EA reference: PA-0012744/01

LPA reference: H11-0866-26

Date: 12 October 2026

**Conversion of detached garage into ancillary annexe for use by family member
36 Market Street, Spalding PE12 9DF**

PROPOSED FIRST
FLOOR PLAN 1:50

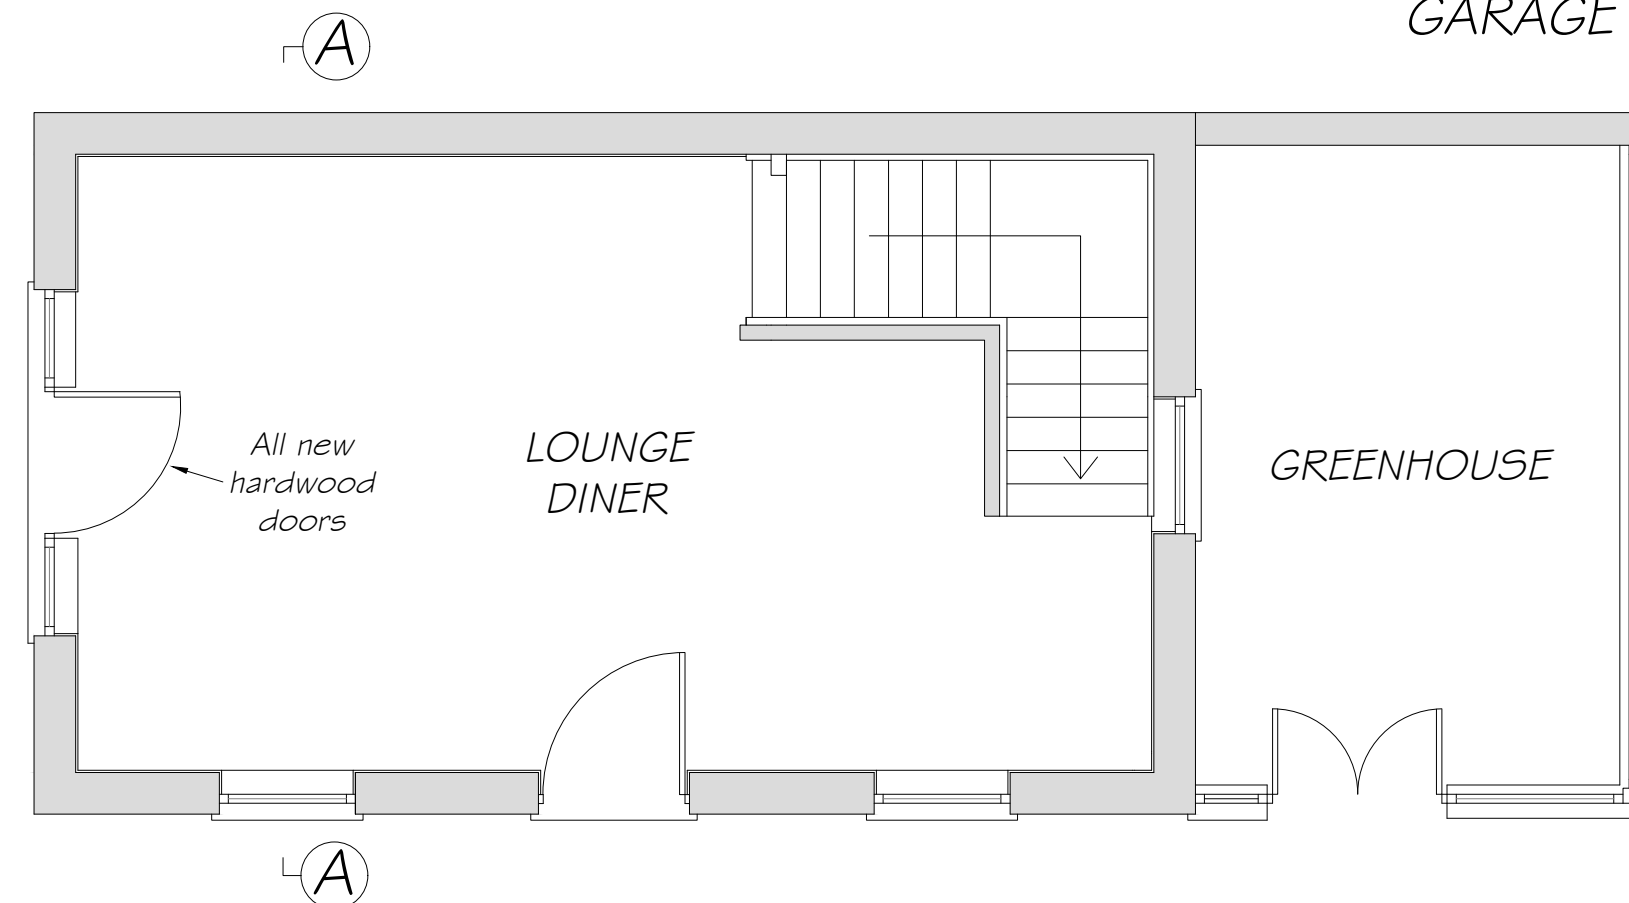
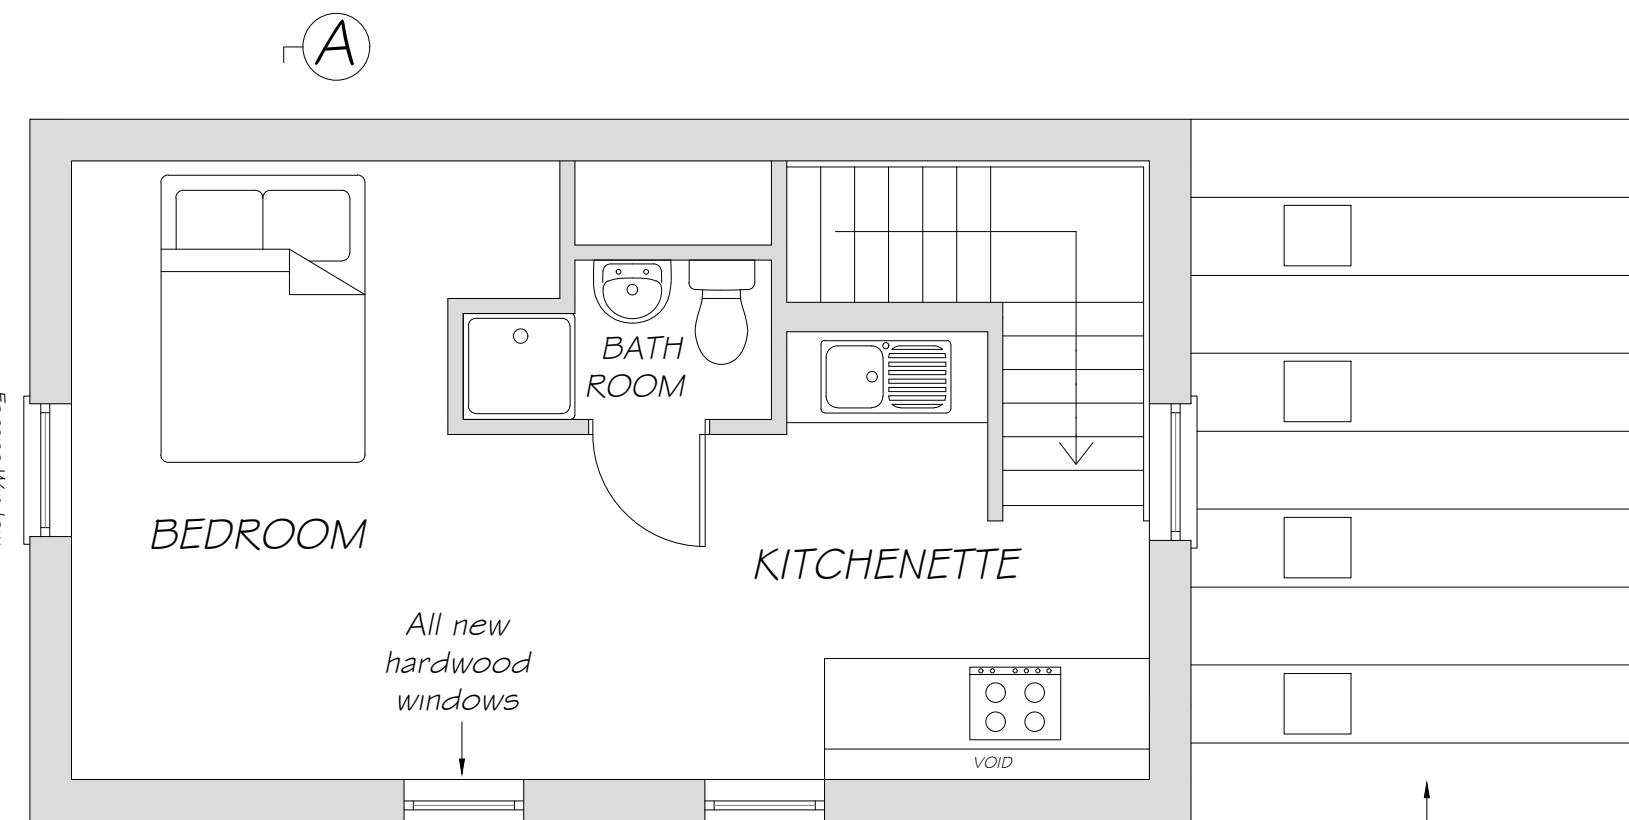
The site has a future hazard classification of 'Danger for Most' (includes the general public) and could experience flood depths of 0.5 – 1 metre arising from a breach in the defences during a flood that has a 0.1% chance of occurring in any one year up to 2115. As the annex is two storeys in height, occupants would have access to safe refuge at first-floor level. In addition, the annex will remain ancillary to the main dwelling, so additional refuge will be available here.
